Response to Planning application from Hertfordshire County Council (T and CP GDP Order 2015)

District ref: 6/2021/2816/HOUSE
HCC ref: WH/10006/2021
HCC received: 1 December 2021
Area manager: Matthew Armstrong
Case officer: Paul Marshall

53 HIGH ROAD HATFIELD AL9 6HS

Extension of existing dropped curb

PROPOSED PLAN WITH EXTENDED
DROPPED KERB & BUSH REMOVAL

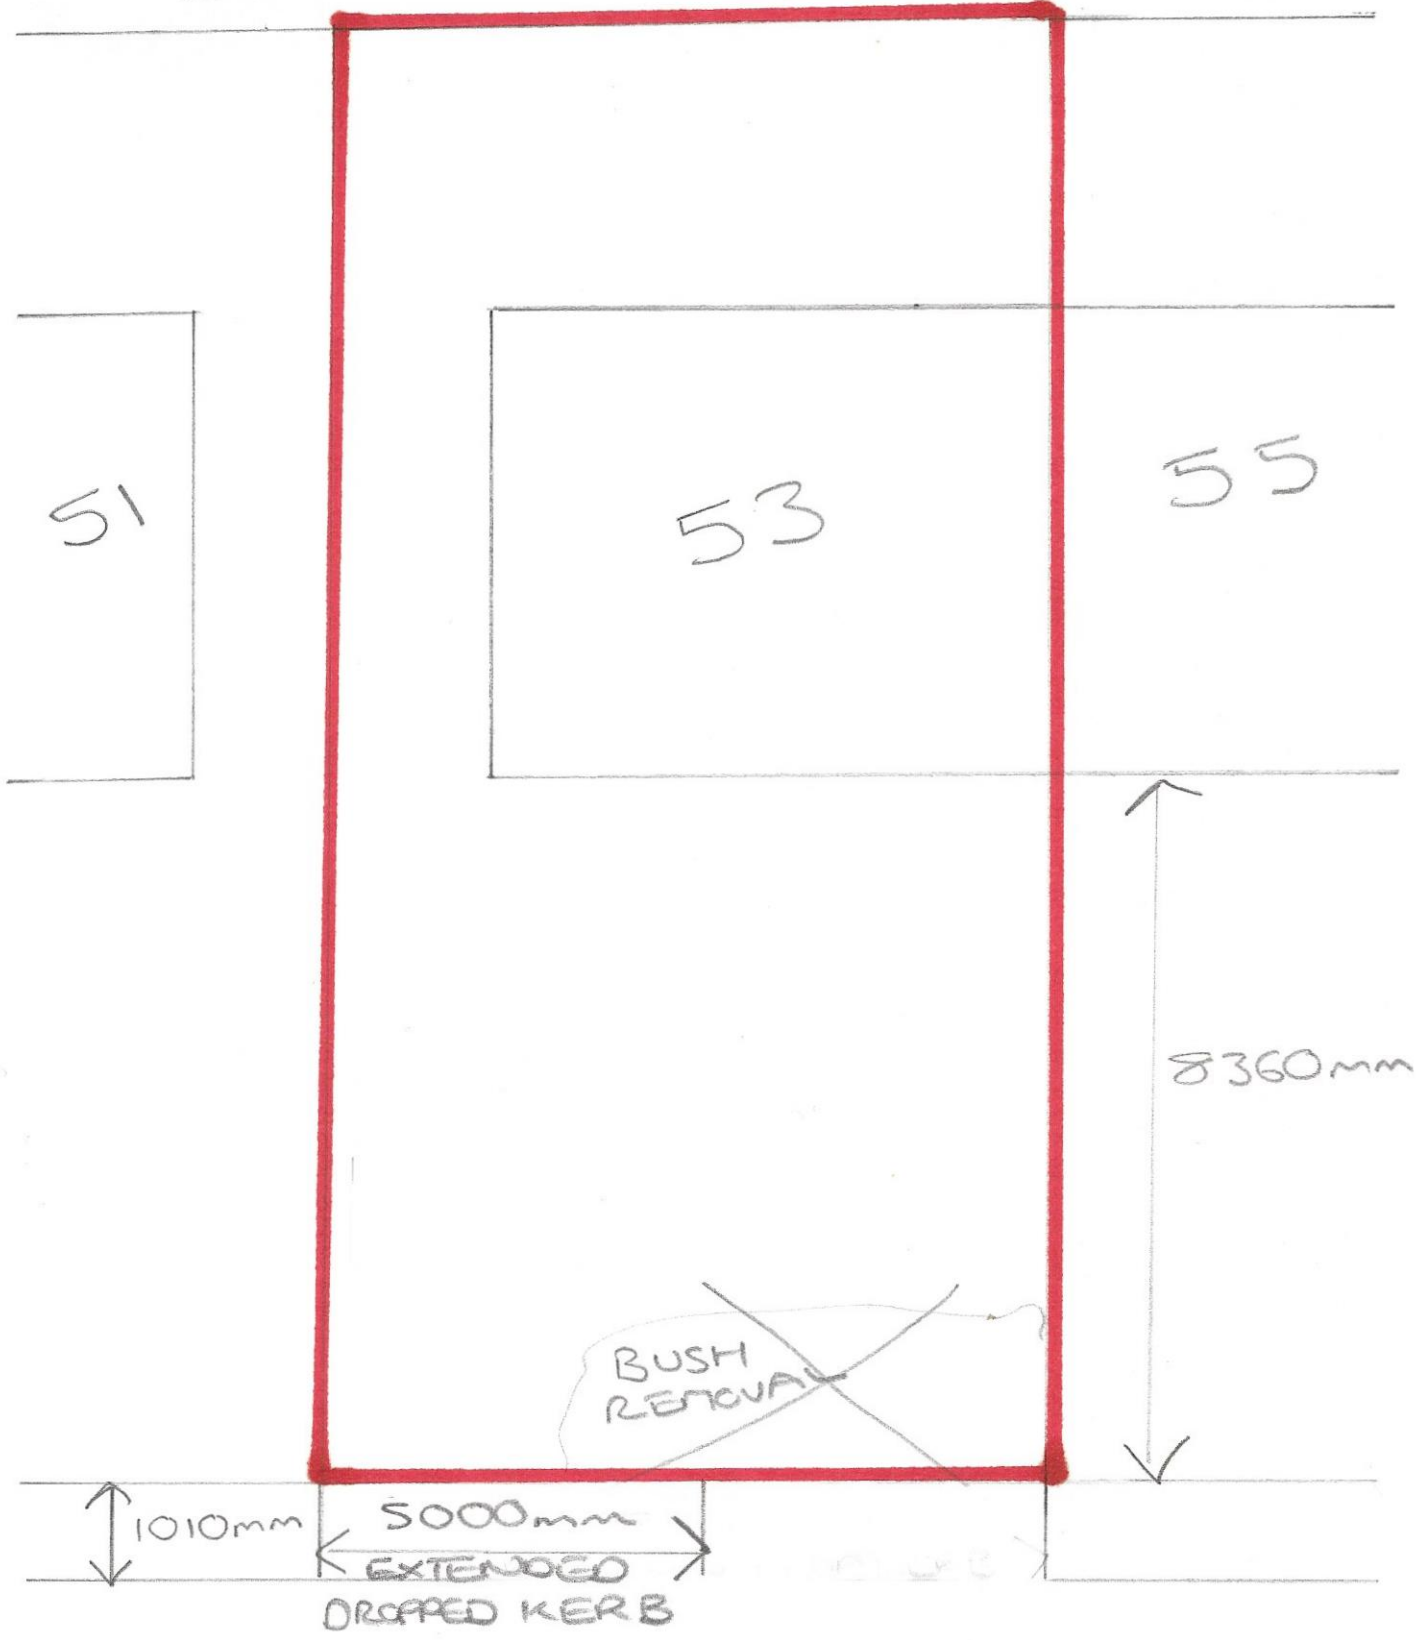
- The proposed dropped kerb extension is too long

The proposal is to extend the existing dropped kerb to 9.6m. HCC Residential Dropped Kerbs Terms and Conditions states:

'If your property already has a dropped kerb, we will only extend the current dropped kerb to a maximum of four flat kerbs (plus two riser kerbs) which equates to 3.6m in total. This is the widest dropped kerb that we will allow' which equates to 5.4m.
